**REQUEST**

Current Zoning: CG (general commercial) and MHP (manufactured home park)  
Proposed Zoning: N2-A(CD) (neighborhood 2-A, conditional)

Approximately 16.91 acres located on the west side of Old Statesville Road and north and south side of Ratcliff Lane, south of West W.T. Harris Boulevard.

The petition proposes the development of up to 198 triplex, quadraplex, and multi-family attached dwelling units. The site is currently developed with a manufactured home park and two single-family detached dwellings.

SHEET NUMBER  
**RZ-1**

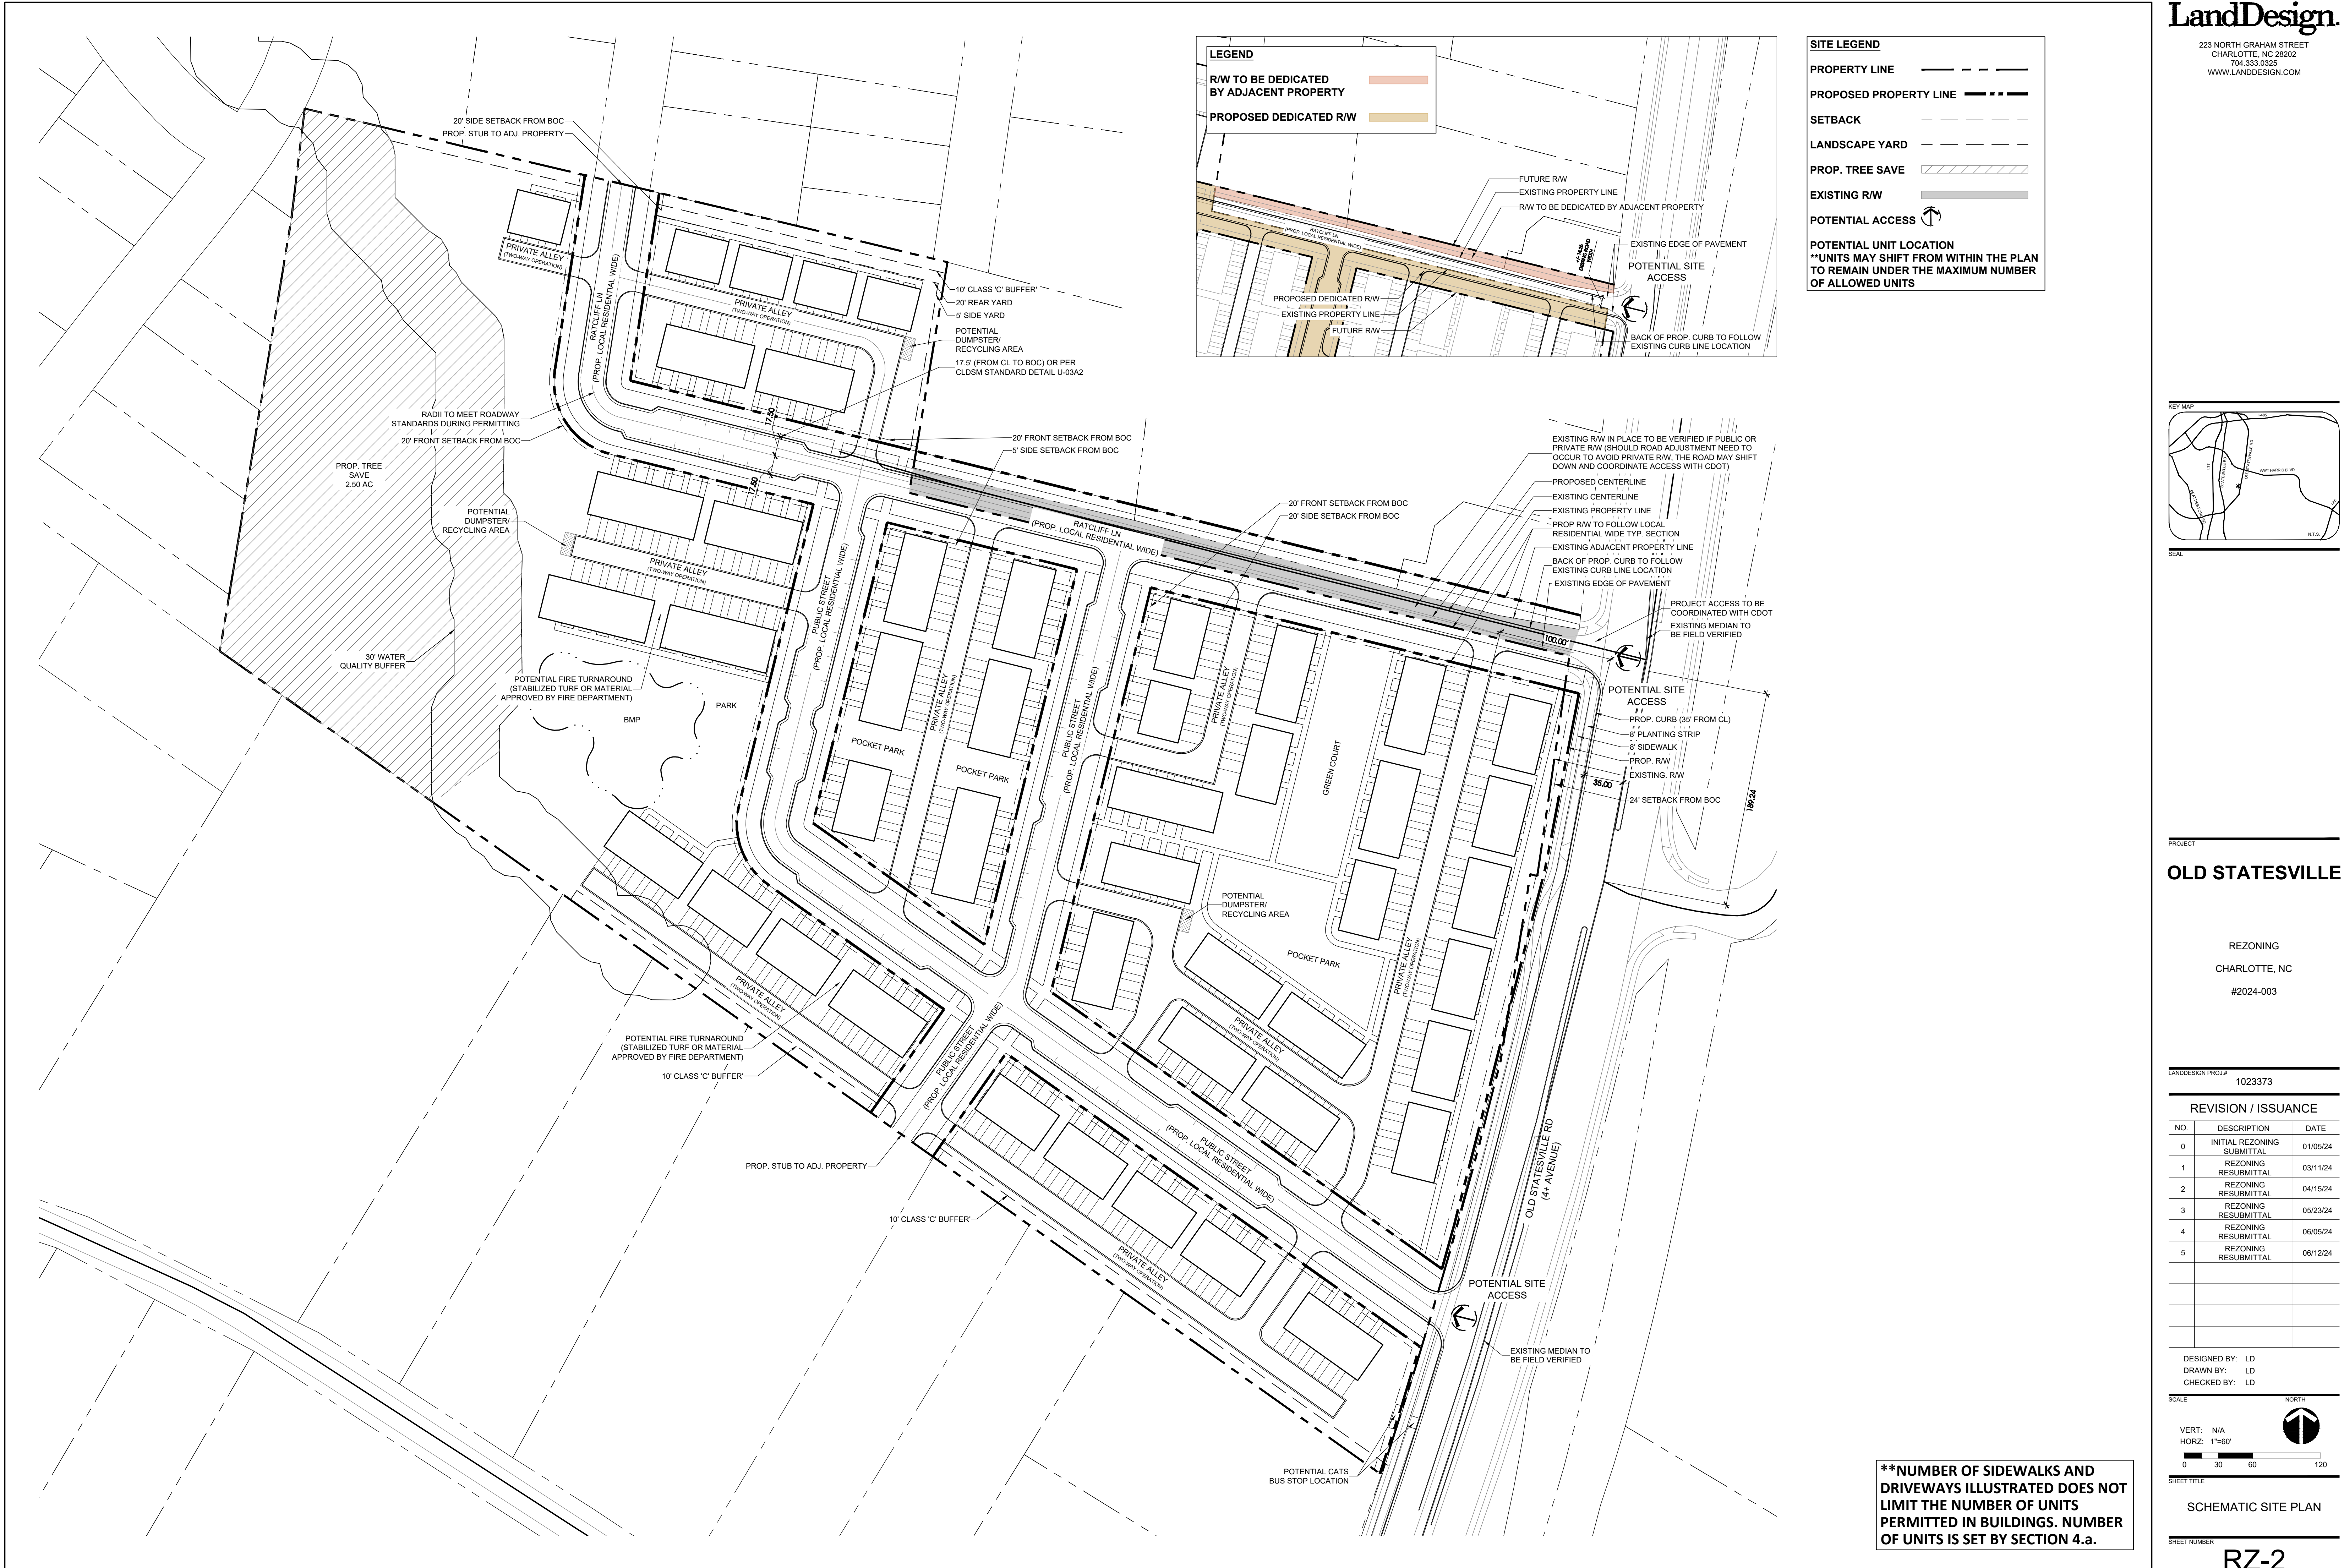
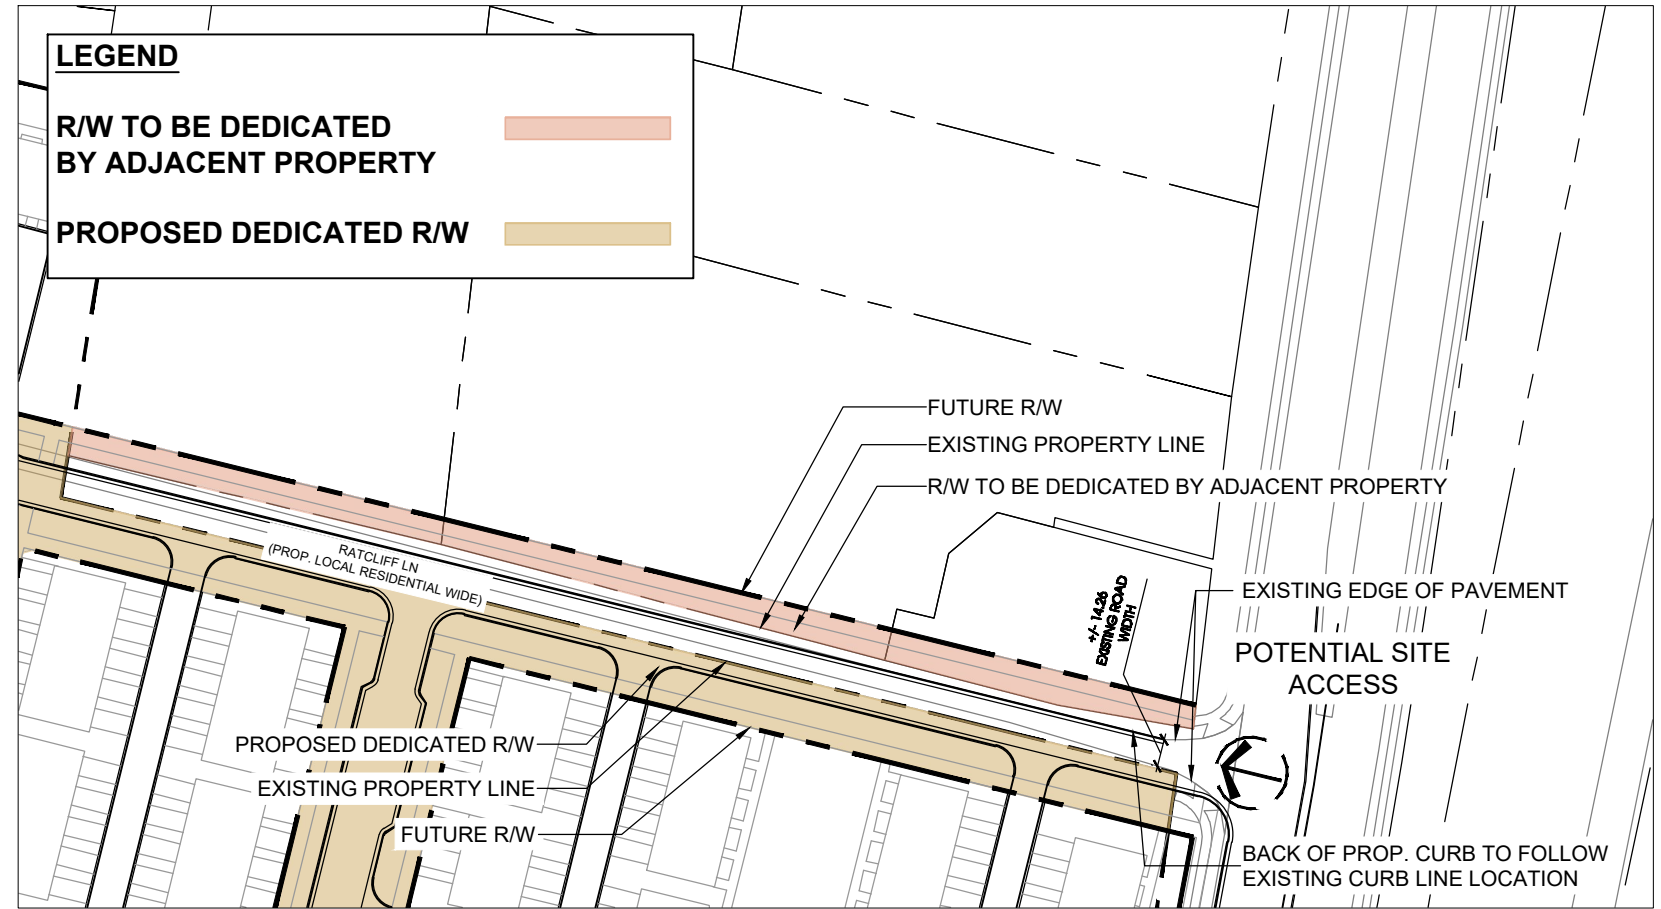
3. Plan sheet RZ-1 specifies a maximum dwelling count of 200 units while the rest of the plan specifies 198.
